Rosefield Solar Farm

Schedule of Changes to the Draft DCO (~~Clean~~) (Tracked)

EN010158/APP/~~8.18.1.2~~
~~October 2025~~ Revision 2
Deadline 1
March 2026
Rosefield Energyfarm Limited

Schedule of Changes to the Draft DCO

DRAWING TITLE:  
**STREETS, RIGHTS OF WAY AND  
 ACCESS PLANS**

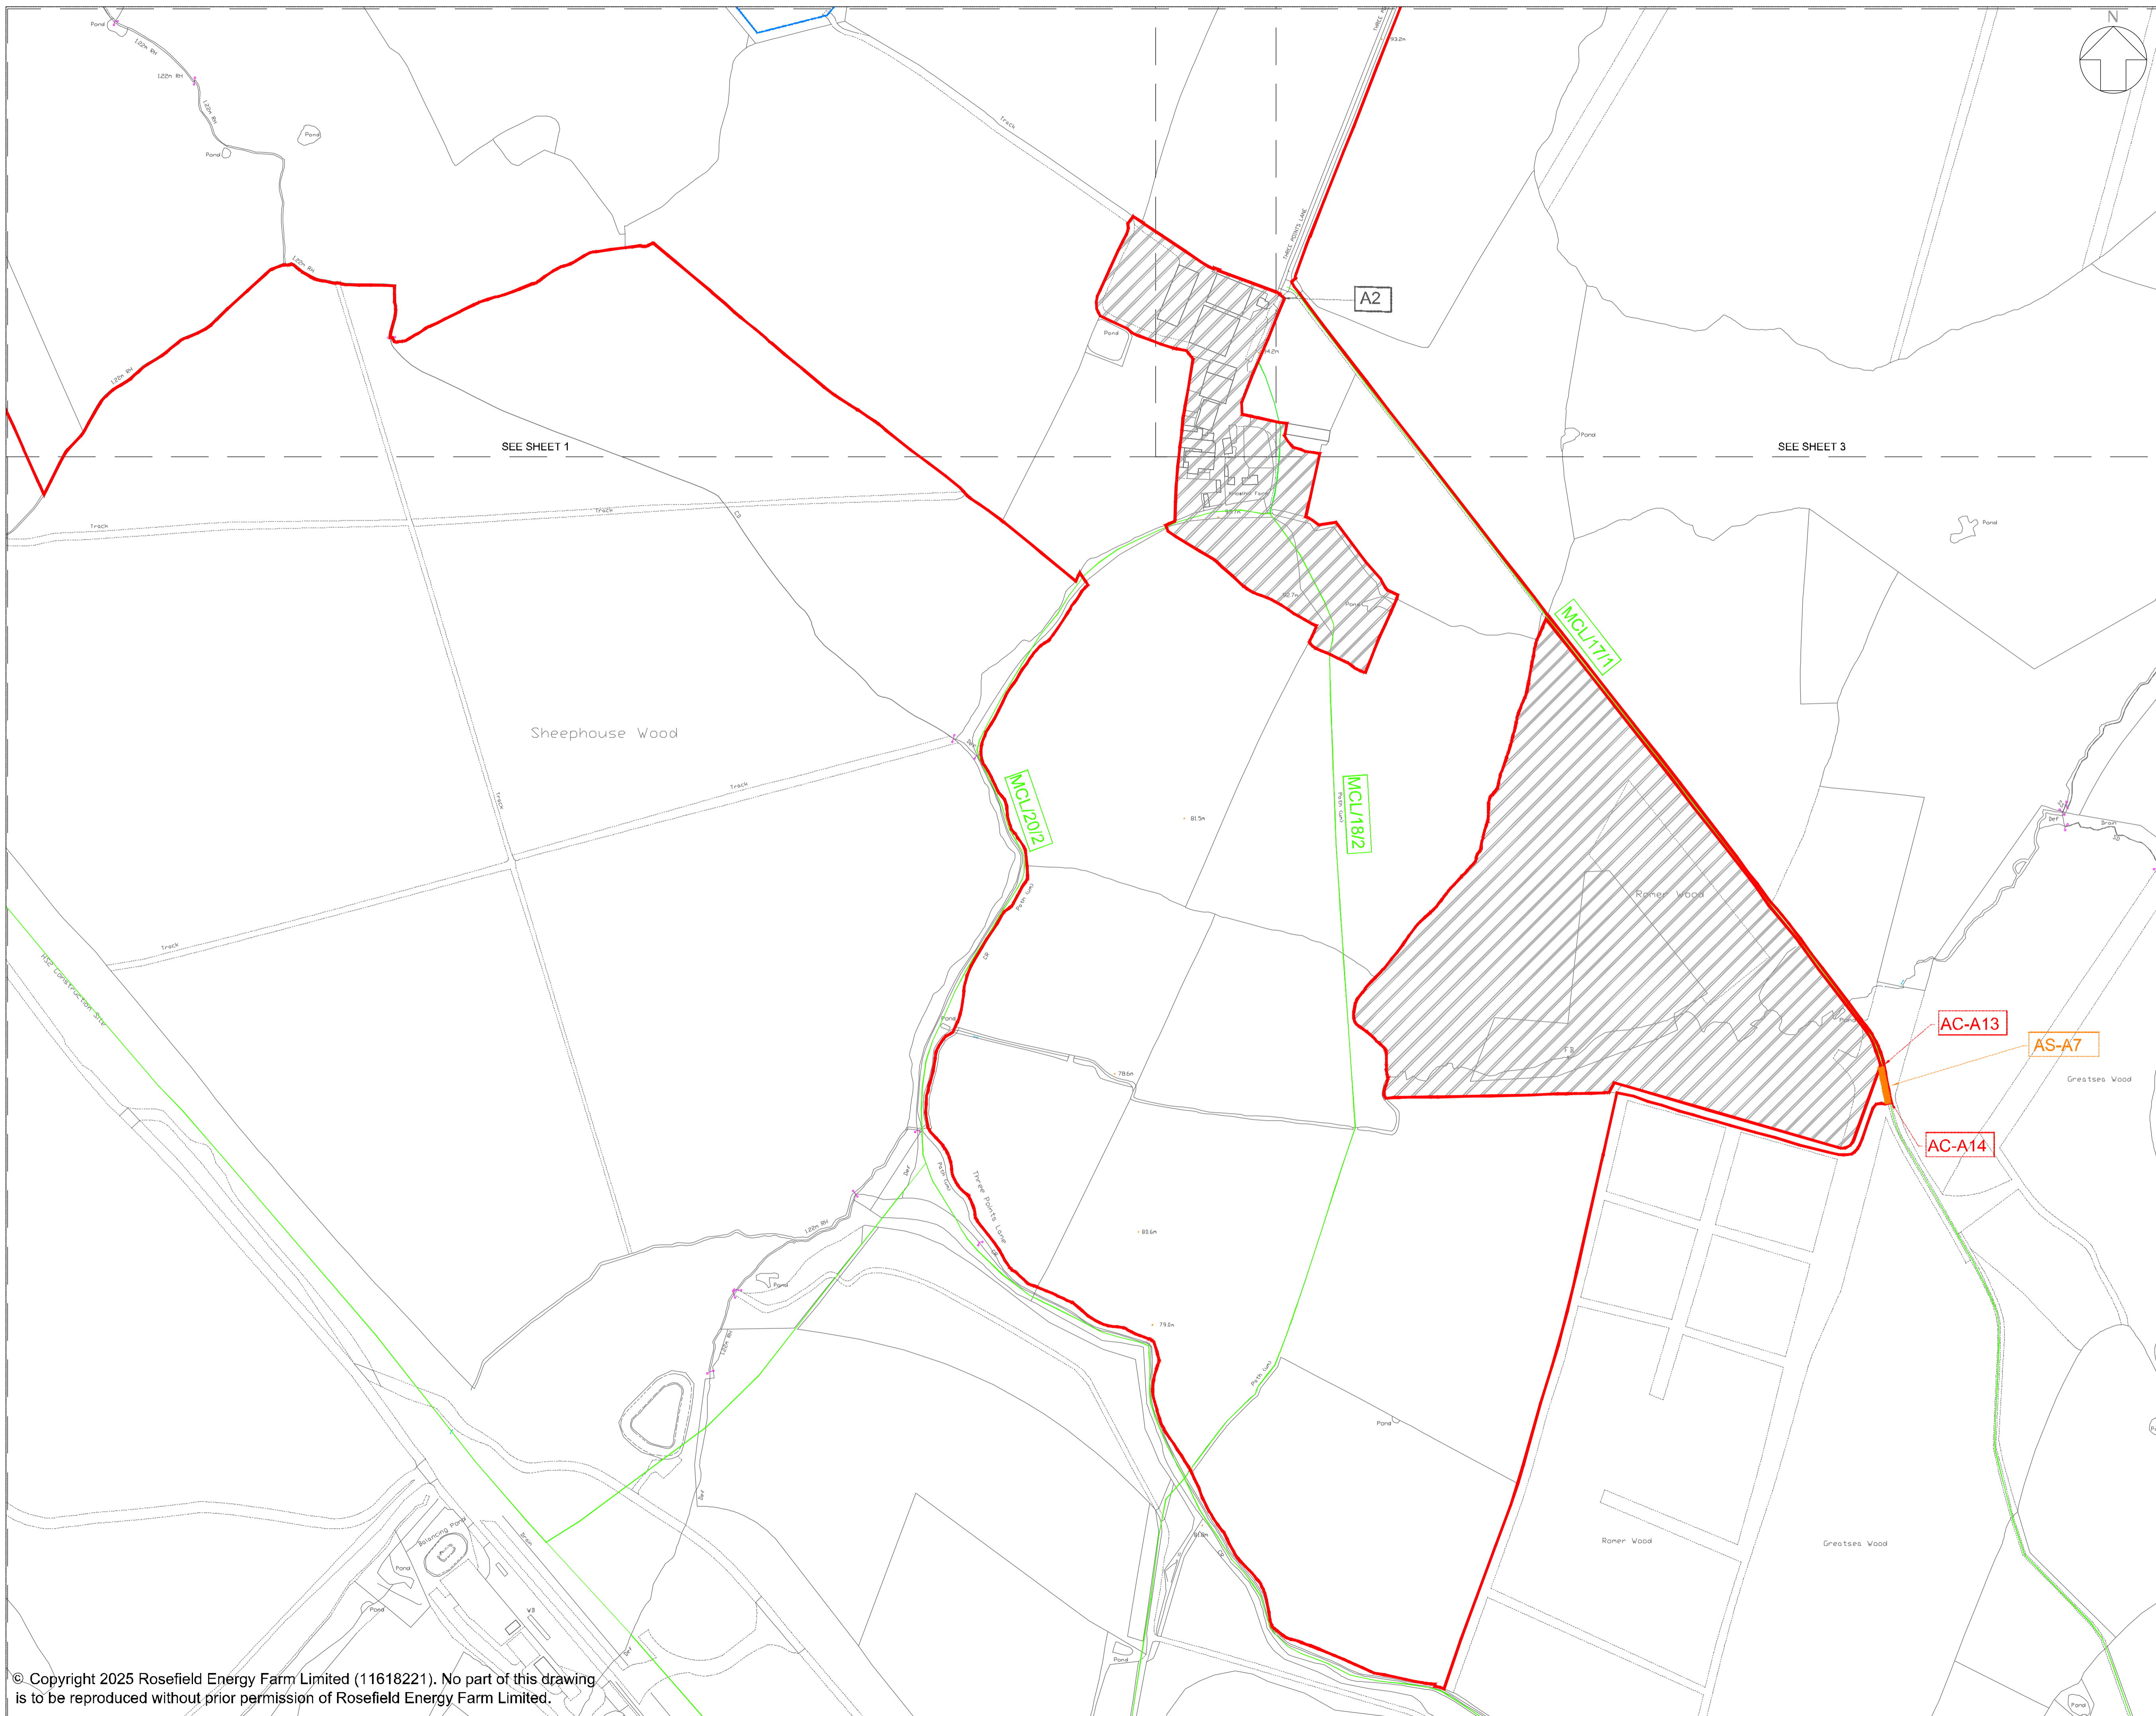
Reference	Change	Reason for Change	Deadline								
	<p><u>(2) The written details under sub-paragraph (1) must be substantially in accordance with the outline drainage strategy.</u></p> <p><u>(3) Any approved strategy must be implemented as approved and maintained throughout the construction and operation of the authorised development.</u></p>	<p><u>relevant representation [RR-012], where each requested to be a consultee.</u></p>									
<p><u>Schedule 2, Requirement 14 (Operational noise)</u></p>	<p><u>14. – (1) No part of Work Nos. 1 to 5 may commence until an operational noise assessment containing details of how the design of that numbered work has incorporated mitigation to ensure the operational noise rating levels as set out in paragraph 13.9.19 of chapter 13 of the environmental statement are complied with for that part has been submitted to and approved by the relevant planning authority.</u></p>	<p><u>Addition of reference to more specific operational noise limits on the face of dDCO.</u></p>	<p><u>1</u></p>								
<p><u>Schedule 6, Part 1 (PRoW to be permanently stopped up and diverted)</u></p>	<table border="1"> <thead> <tr> <th><u>(1) Area</u></th> <th><u>(2) Public right of way to be stopped up</u></th> <th><u>(3) Extent of stopping up</u></th> <th><u>(4) New public right of way to be substituted / provided</u></th> </tr> </thead> <tbody> <tr> <td><u>District of Buckinghamshire</u></td> <td><u>SCL/12/2</u></td> <td><u>For a distance of 320 190 metres between points PE-A7 PE-A10 and point SW04 as shown on sheet 1 of the streets, access and rights of way plans.</u></td> <td><u>New public footpath to be provided between points PE-A7, PE-A5 and its intersection with SCL/12/1 as shown by a cyan line on sheet 1 of the streets, rights</u></td> </tr> </tbody> </table>	<u>(1) Area</u>	<u>(2) Public right of way to be stopped up</u>	<u>(3) Extent of stopping up</u>	<u>(4) New public right of way to be substituted / provided</u>	<u>District of Buckinghamshire</u>	<u>SCL/12/2</u>	<u>For a distance of 320 190 metres between points PE-A7 PE-A10 and point SW04 as shown on sheet 1 of the streets, access and rights of way plans.</u>	<u>New public footpath to be provided between points PE-A7, PE-A5 and its intersection with SCL/12/1 as shown by a cyan line on sheet 1 of the streets, rights</u>	<p><u>Reduction in extent of stopping up to SCL/12/2 to address Buckinghamshire Council’s relevant representation [RR-026] to avoid creation of a ‘dead-end’.</u></p>	<p><u>1</u></p>
<u>(1) Area</u>	<u>(2) Public right of way to be stopped up</u>	<u>(3) Extent of stopping up</u>	<u>(4) New public right of way to be substituted / provided</u>								
<u>District of Buckinghamshire</u>	<u>SCL/12/2</u>	<u>For a distance of 320 190 metres between points PE-A7 PE-A10 and point SW04 as shown on sheet 1 of the streets, access and rights of way plans.</u>	<u>New public footpath to be provided between points PE-A7, PE-A5 and its intersection with SCL/12/1 as shown by a cyan line on sheet 1 of the streets, rights</u>
